WCW05306

RESPONSE TO SUBSIDENCE RELATED SUBMISSIONS FOR MOD2 AT WONGAWILLI COLLIERY

Wollongong Coal Limited (WCL) has applied to modify the Nebo Area Project Approval 09_0161 (MOD2) to include continuation of development of the main headings known as the Western Driveages or NW Mains in a similar layout to that currently approved. WCL has received submissions from government agencies relating to this proposed modification. WCL commissioned SCT Operations Pty Ltd (SCT) to prepare a response to subsidence-related issues raised in these submissions. This letter report presents our response.

Figure 5: Plan of Proposed MOD2 Layout relative to geological structure and existing mine workings.

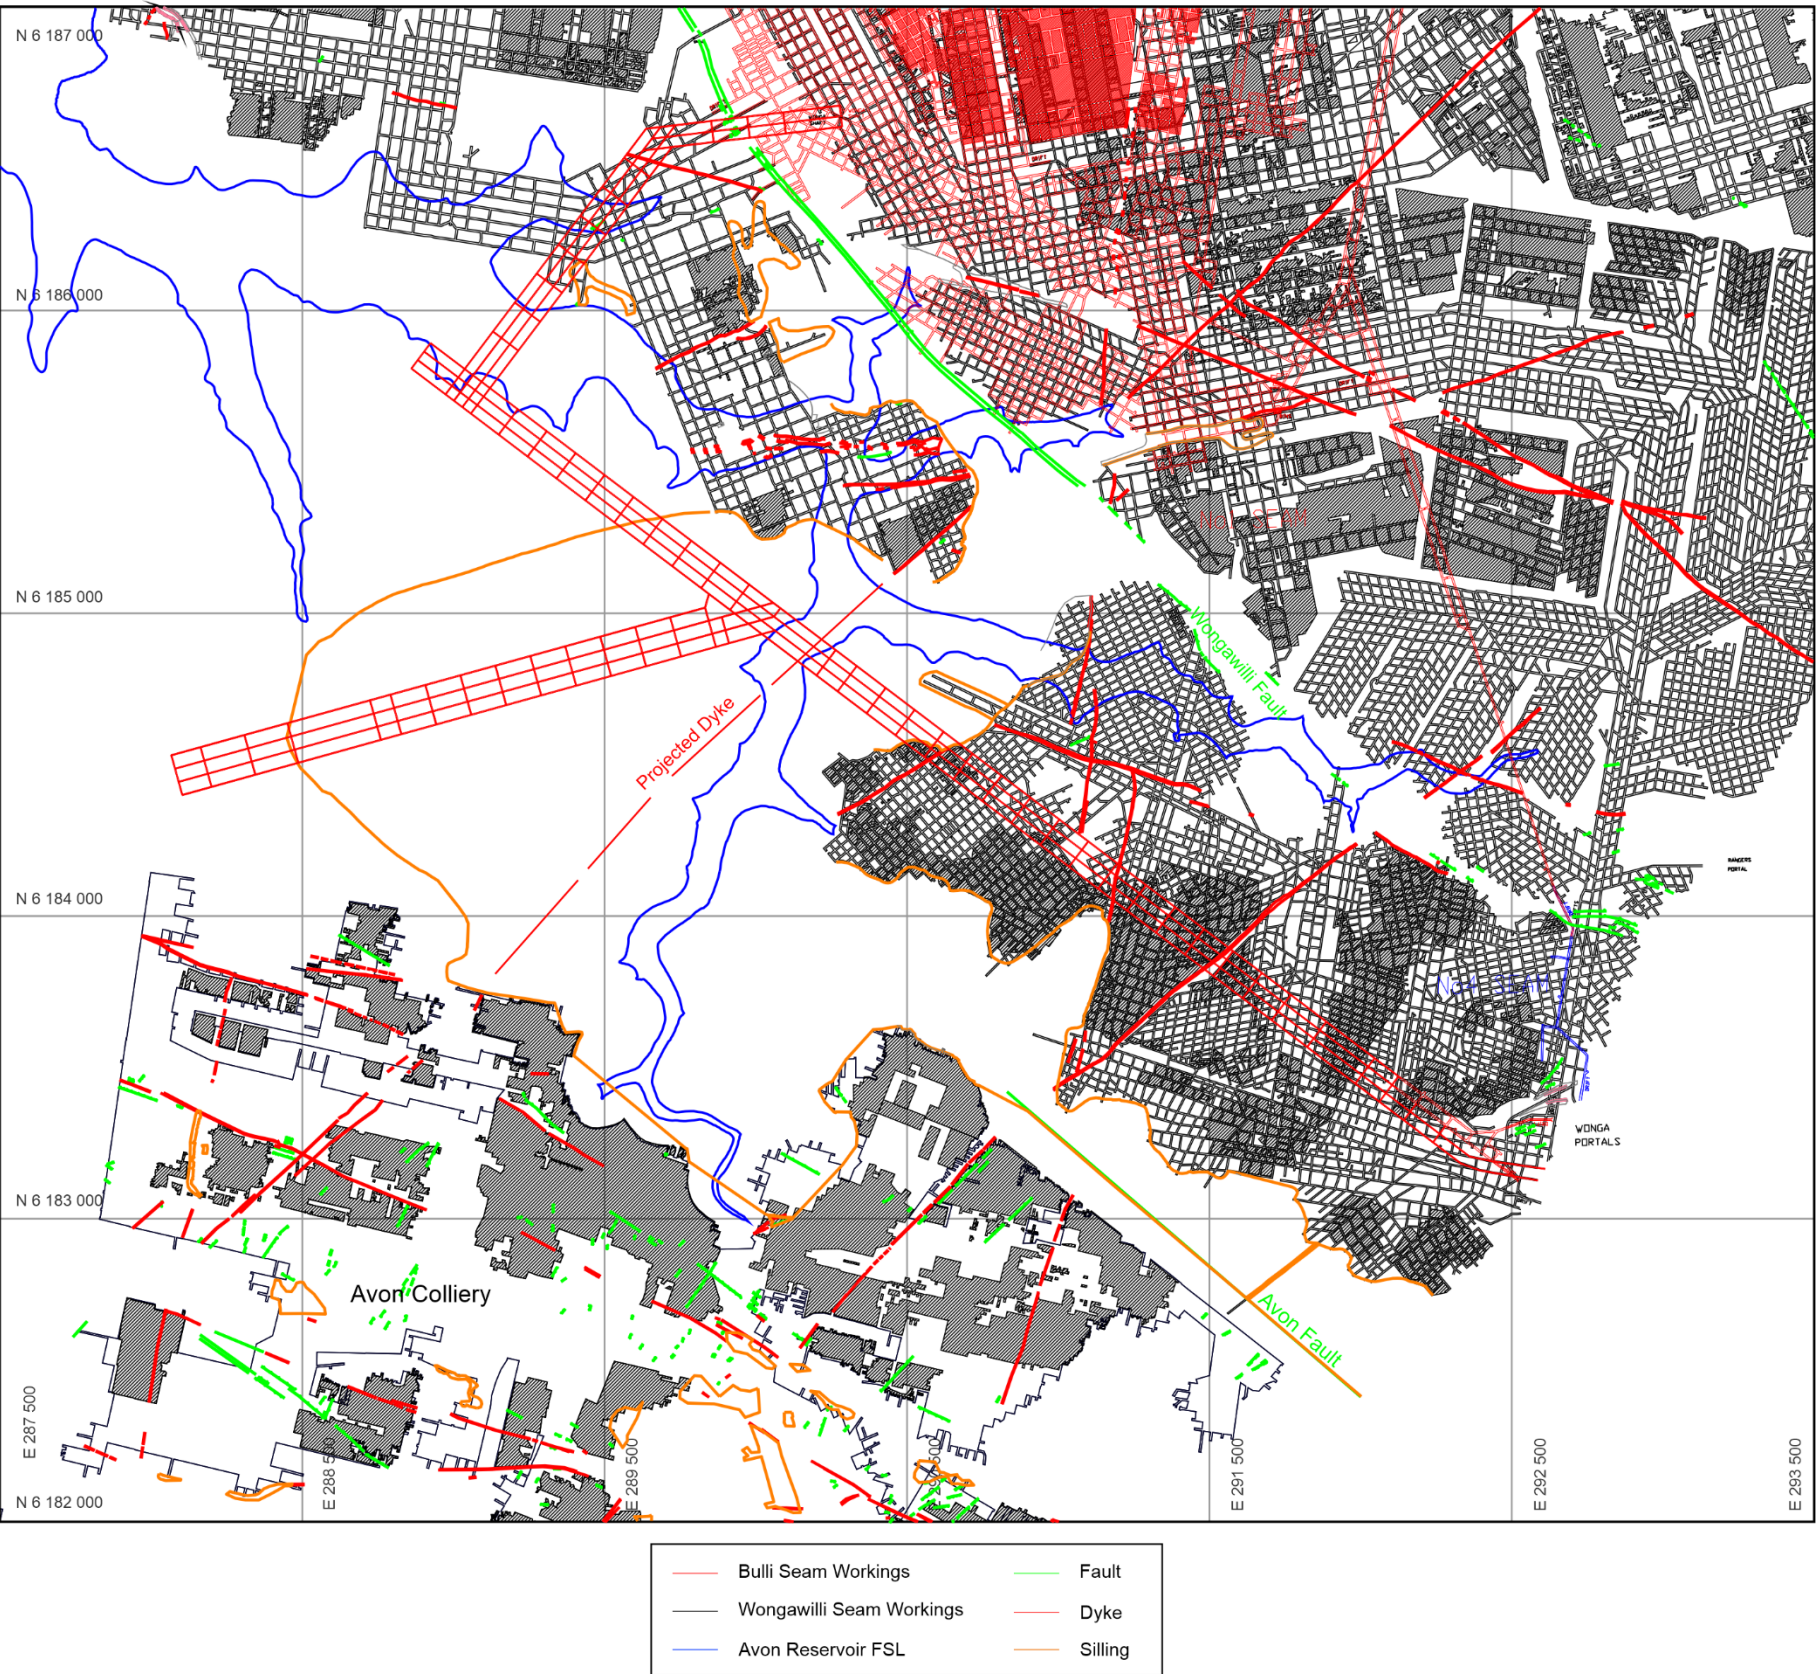
WaterNSW (2021) has requested further consideration of the impact of mining through the Wongawilli Fault and the dyke located below Avon Reservoir. The potential for inflow through these structures is discussed in Section 6 of SCT (2020).

There are also many intersections of the fault plane(s) or steeper ground associated with the fault from everyday driveages in both the Wongawilli and Bulli Seams. Some of these intersections are in close proximity to where the Wongawilli Fault crosses the reservoir in the Flying Fox No1, No2 and No3 arms of the storage. No significant inflows have been observed from the drifts or other intersections of the Wongawilli Fault.

It is anticipated that the ground conditions where the proposed headings cross the Wongawilli Fault will be able to be managed without undue difficulty. The coal mining and Avon-Illawarra Tunnel driveage experience supports this expectation. The crossing point for the proposed headings is approximately 400m from the FSL of Avon Reservoir. No interaction effects with the reservoir are expected.

The proposed MOD2 roadways are designed to cross the Wongawilli Fault above existing Bulli to Wongawilli Seam cross-measures drifts driven in 1975-77 to service the mine operations until this section of the mine was sealed in 1999.
